BOGNOR NORTHERN RELIEF ROAD, PHASE 1

“PROPOSED PLAYING FIELD ACCESS” (Version 2.0)

Road Safety Audit Combined Stage 1 & Stage 2 – Detailed Design

Designers’ Response- Glenn Tregillis May 2015

TITLE: SPORTS PITCH DRAINAGE AND ACCESS STRATEGY

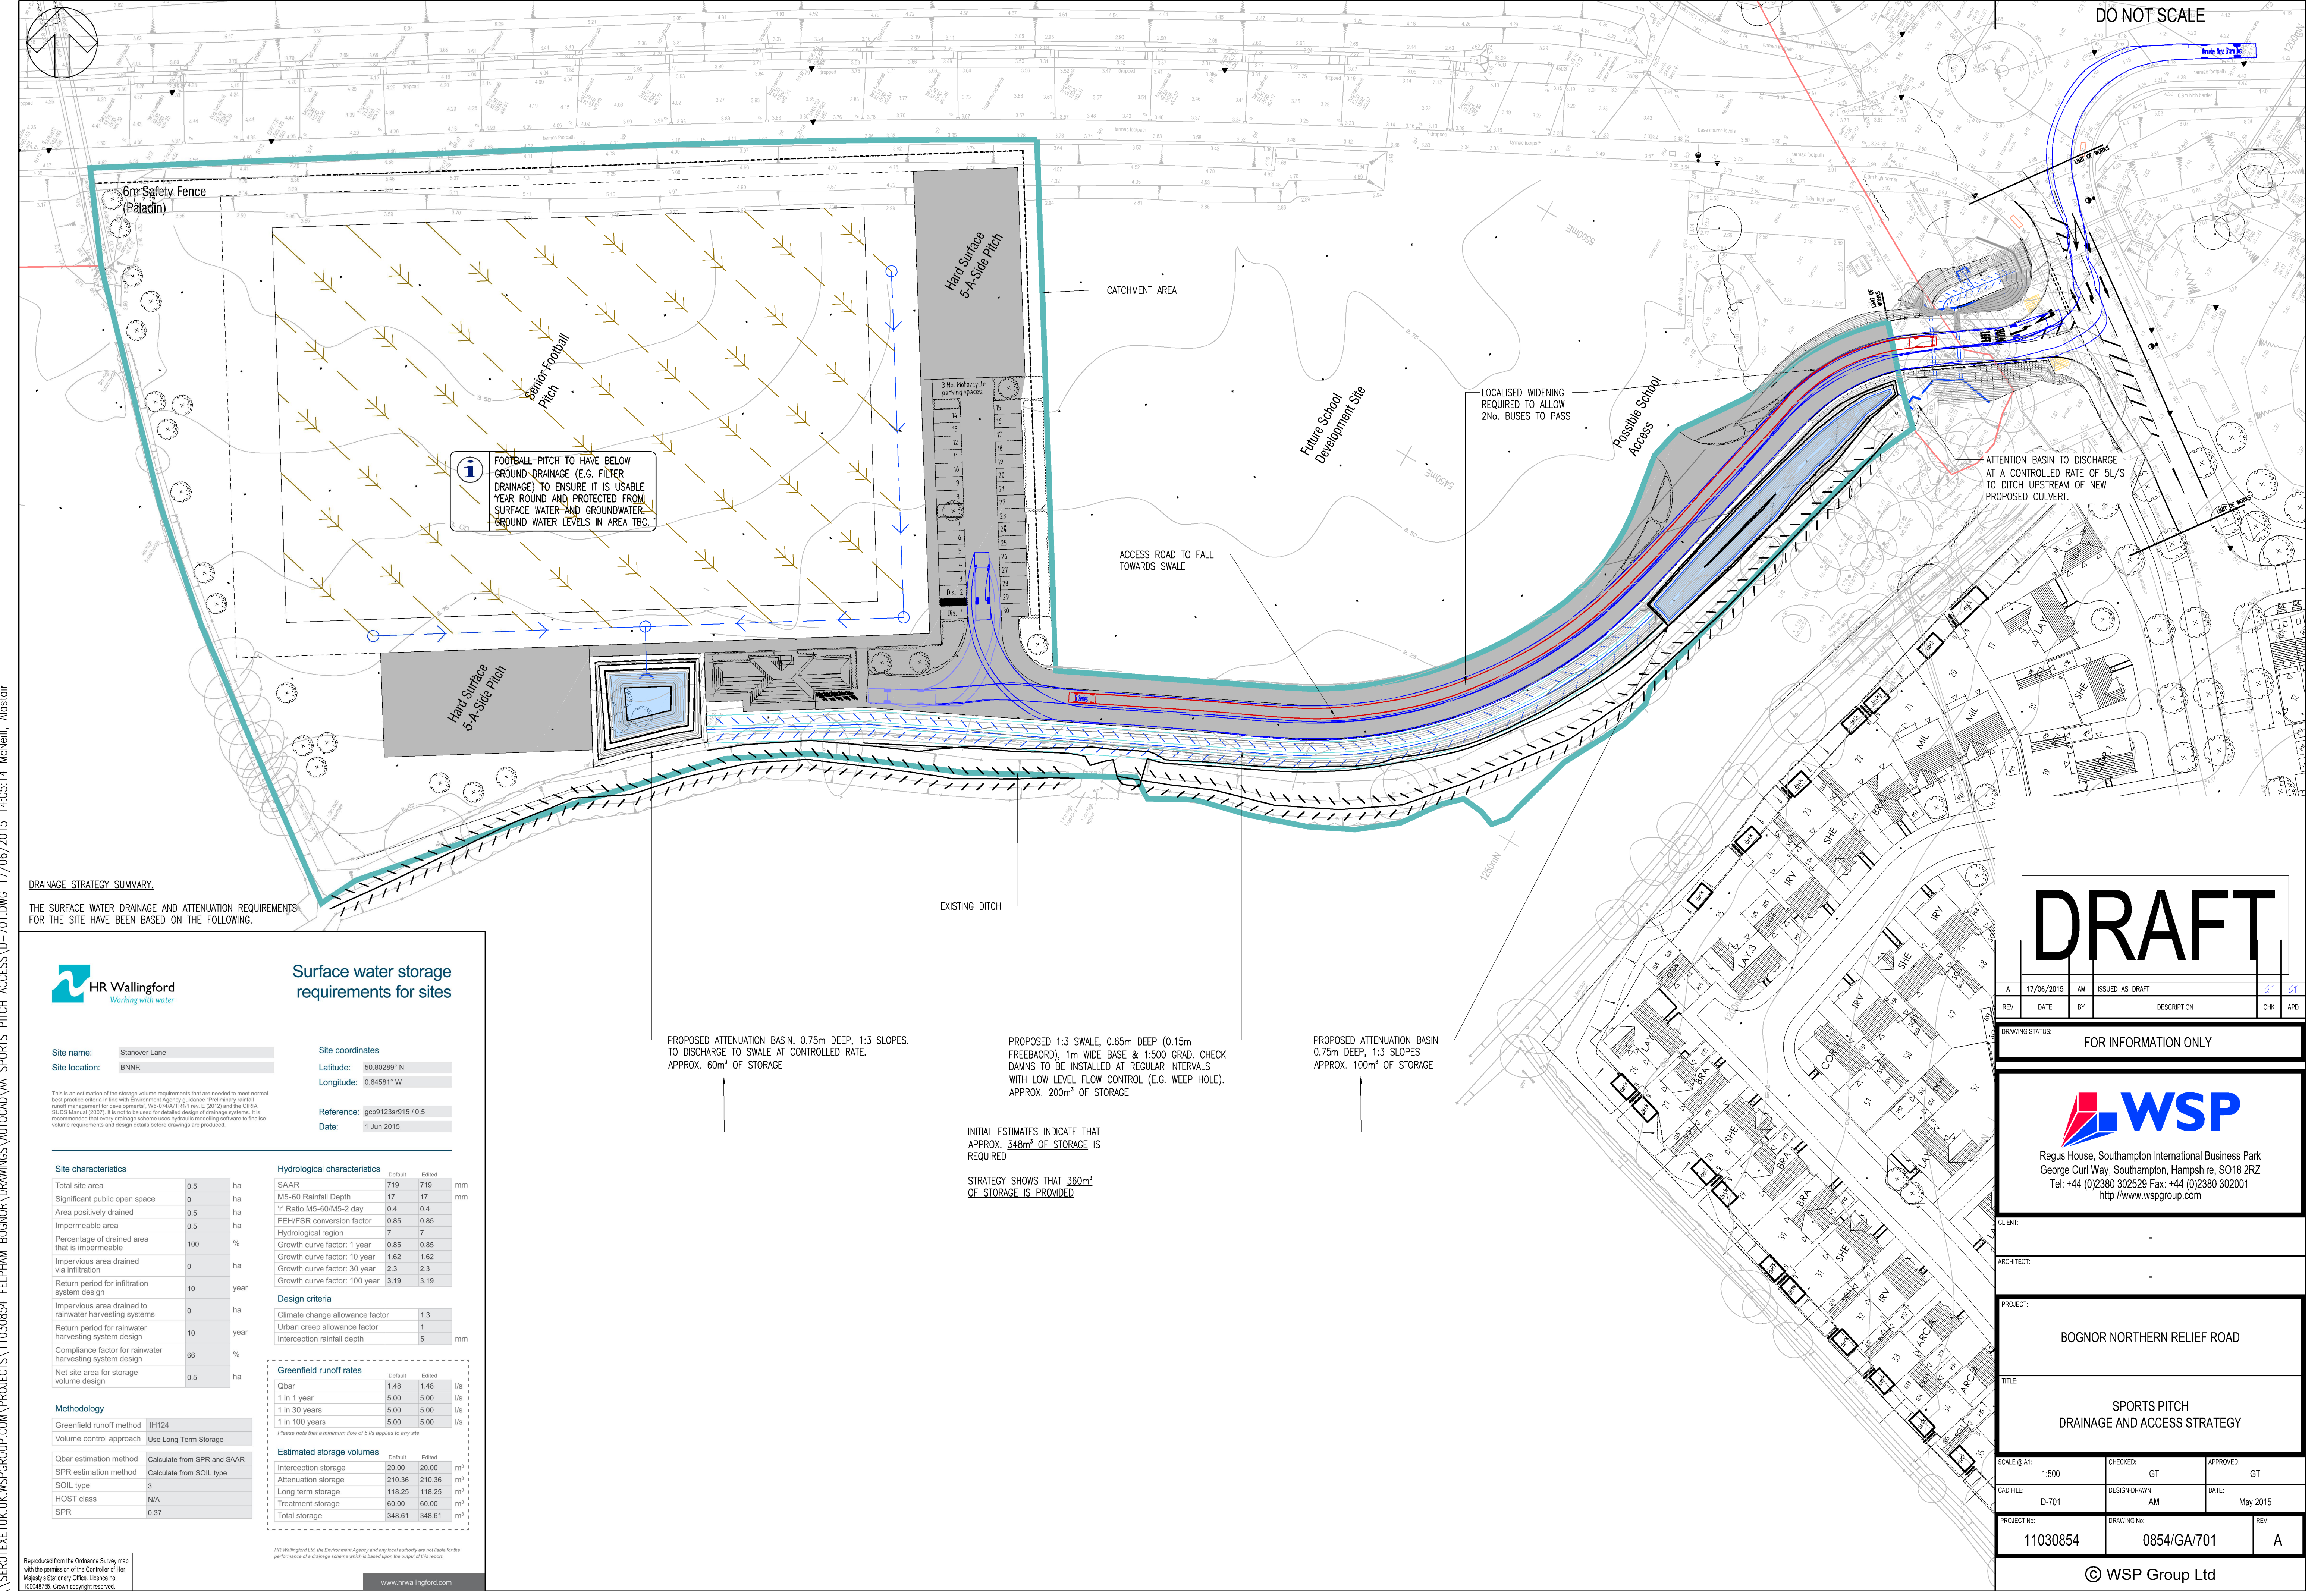
The proposed access road appears to be located where the adjacent land is below the level of existing carriageway, but no gullies appear to be included within the design, especially at the proposed dropped kerb crossing points where pedestrians stepping into the carriageway to cross may need to step across flowing surface water or risk of crossing ponding which may give rise to hazardous conditions at times of icy weather.

The proposed Playing Field Access Road may need to be checked and appropriate gullies provided at the upstream side of the pedestrian dropped kerb crossing points.

The proposed access arrangements have been revisited with the inclusion of additional road gullies.

TITLE:
SPORT PITCH ACCESS GHOST ISLAND OPTION

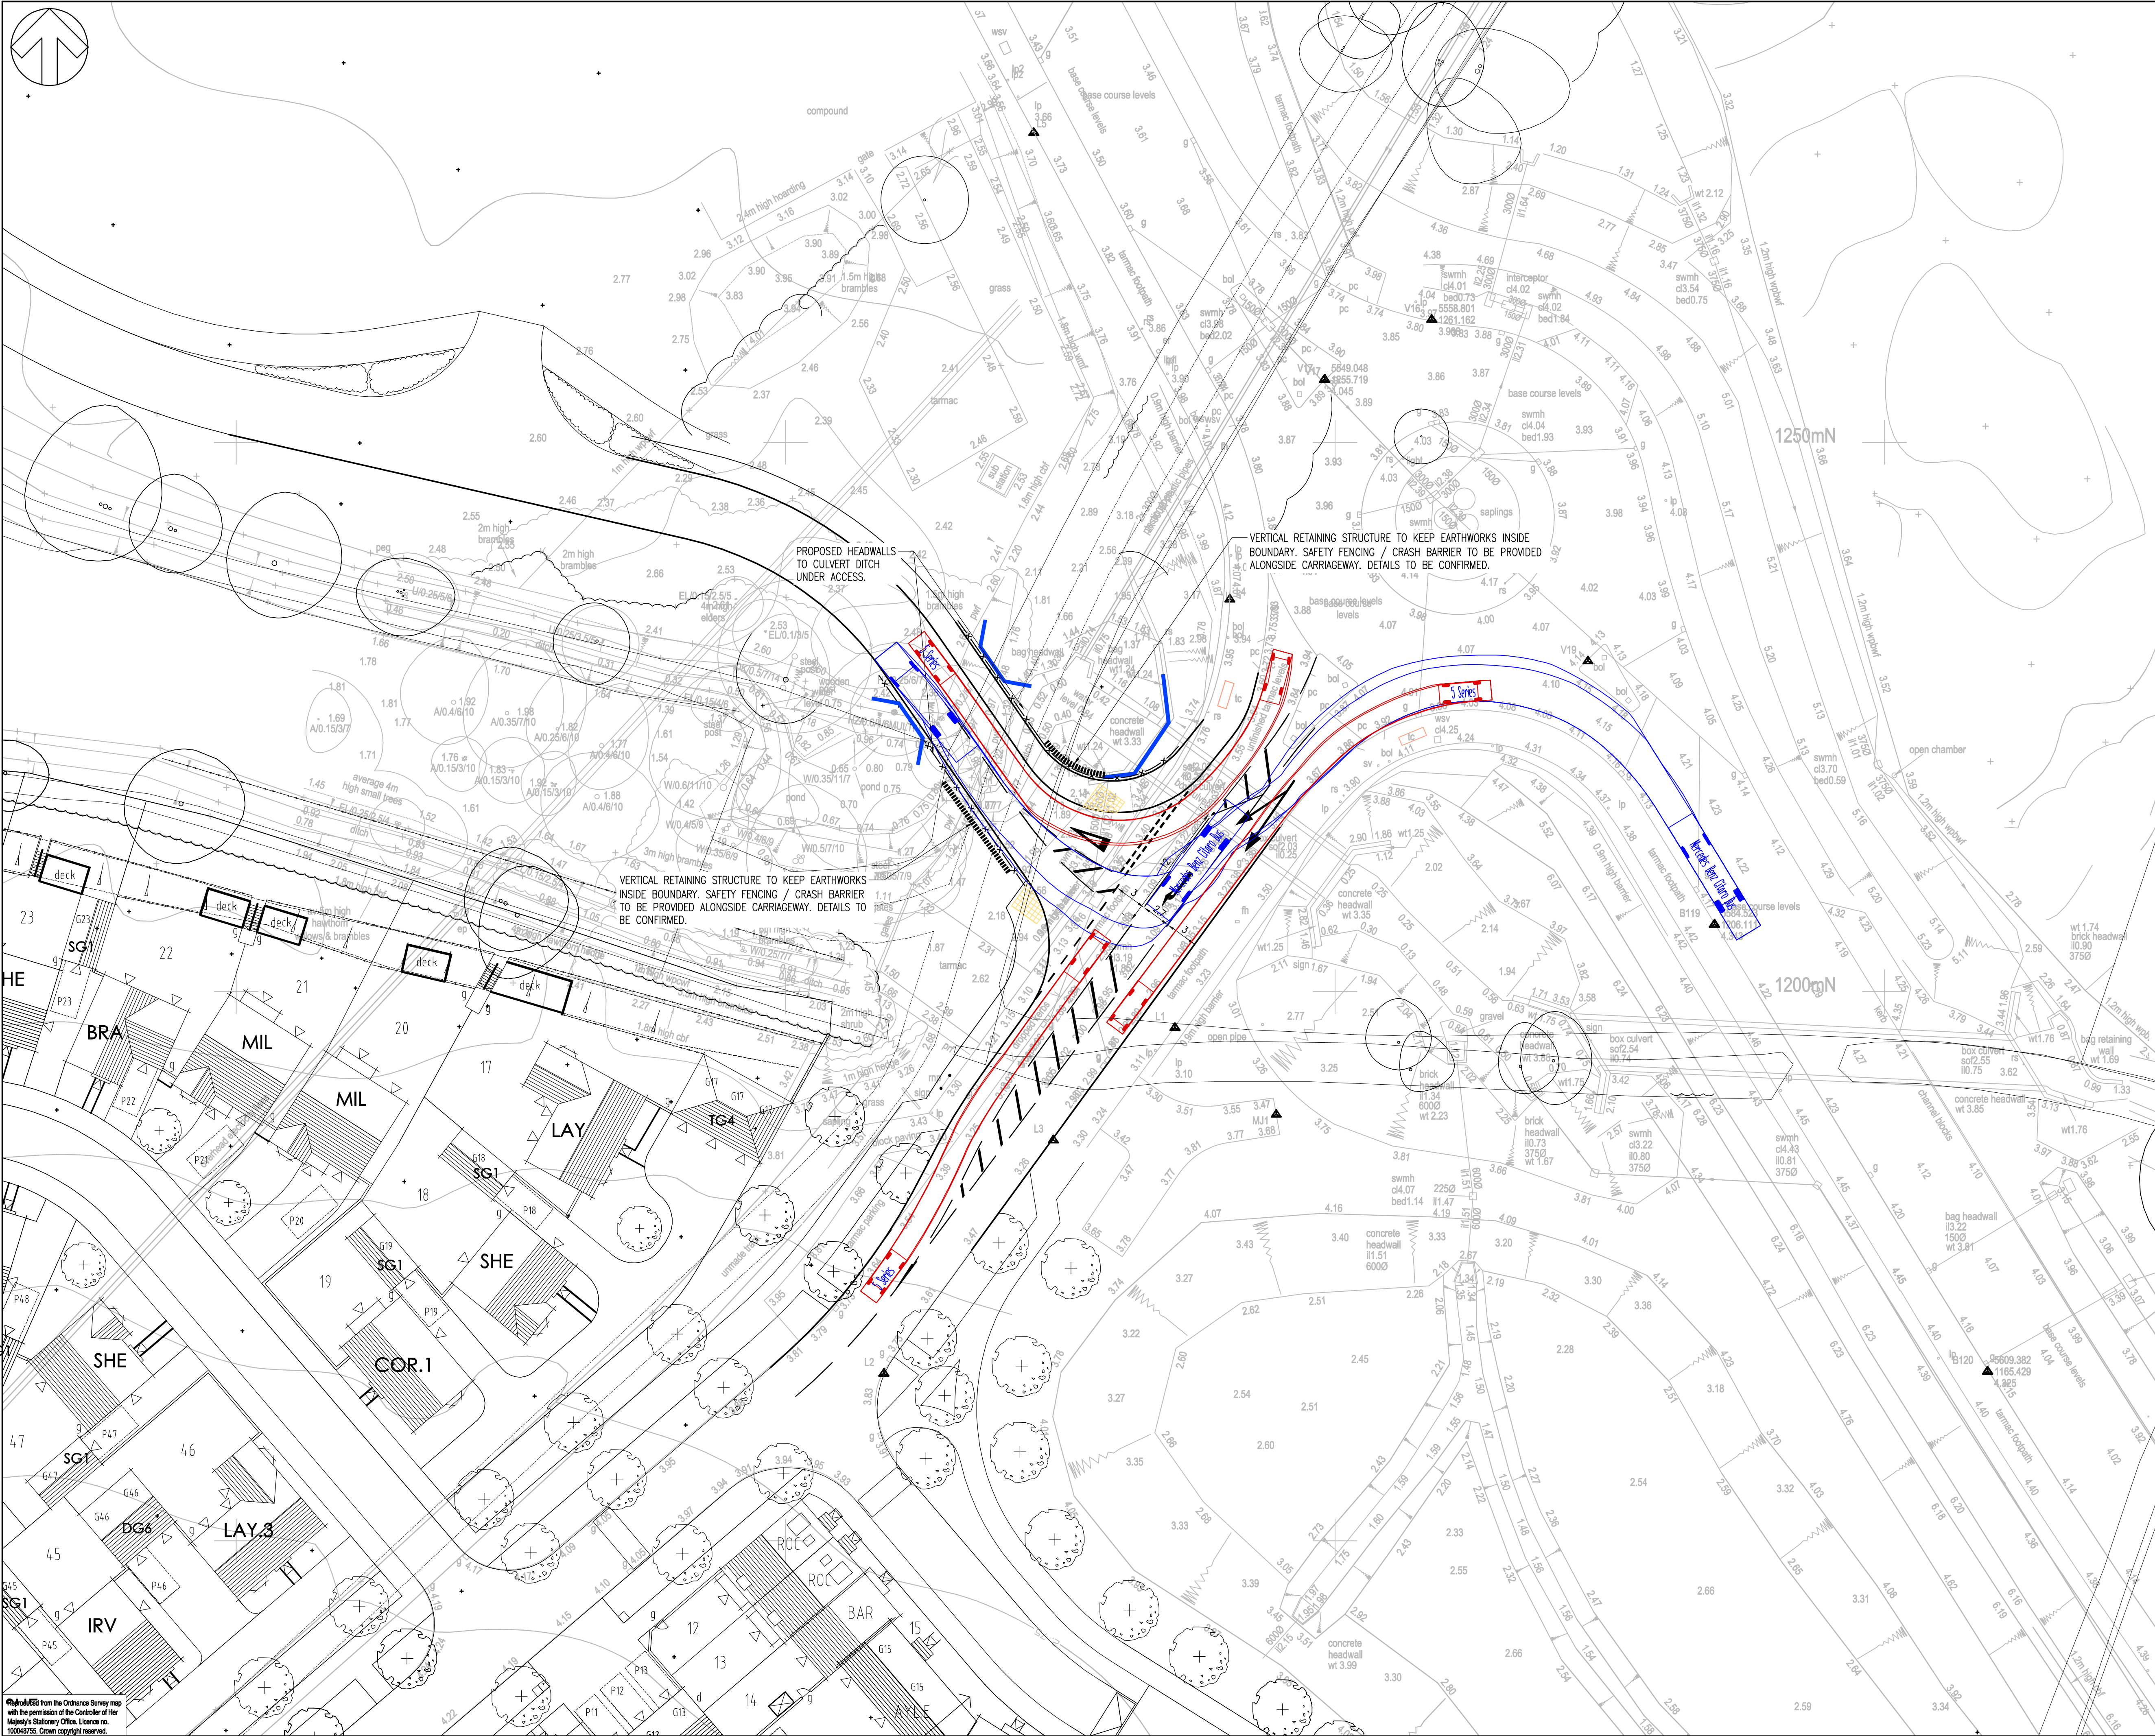
At the existing westbound carriageway of the Northern Relief Road approaching the Stanover Lane Roundabout, the proposed Playing Field Access within the Southern Arm will be hidden from view of westbound drivers by the combination of current Vehicle Restraint Barriers on the inner radius of the horizontal exit curvature and the adverse vertical down gradient of the carriageway into the housing Development, thus creating lack of sufficient clear forward visibility for westbound drivers turning left towards the location of the proposed access to the Playing Fields and Potential School Premises. These conditions are also likely to be exacerbated by the future growth of the planting currently located behind the VR barriers.

The proposed access arrangements should be revisited with a view to re-assessing the potential traffic flows at the junction and of sufficiently widening the carriageway locally to provide a segregated area at the centre of carriageway for right turning vehicle to move into and potentially wait for suitable gap if required to do so, whilst the current planting at the rear of the Vehicle Restraint System on the inner radius curvature should be removed.

The proposed access will be constructed immediately south of the existing roundabout and its splitter island, where currently there is no provision of waiting space for vehicles to wait prior to turning right into the access. Furthermore, the swept path diagram of the single deck bus is shown overrunning the offside exit lane from the roundabout, where collision with vehicles leaving the roundabout may occur and also appears to overrun the splitter island and risks kerb impact.

The proposed access position should be revisited with a view to shifting the access bellmouth further southwards and widening the carriageway of the Southern Arm of Stanover Lane sufficiently to provide space for a short right turn lane for access to the Playing Fields and Potential School Premises.

On the drawing numbered “ATR/100 Rev A” indicating Vehicle Swept Path Analysis, the proposed footway at the north side of the access bellmouth appears to coincide with the outline of the southern side of the existing culvert headwall. In addition, it is not clear how pedestrians may be protected from falling into the culvert or deep water below.

The proposed access bellmouth should be revisited with a view to shifting it further southwards to sufficiently clear the existing headwall and any realignment of the existing ‘Vehicle Restraint System’ and to preserve its working width.

The proposed access arrangements have be revisited with the inclusion of right hand ghost island with adequate storage for a bus.

Vehicle Restraint System shall be altered to provide for the access.

The proposed access arrangements have be revisited with the inclusion of right hand ghost island with adequate storage for a bus.

The proposed access arrangements have been revisited with the inclusion of a level platform at the bellmouth.
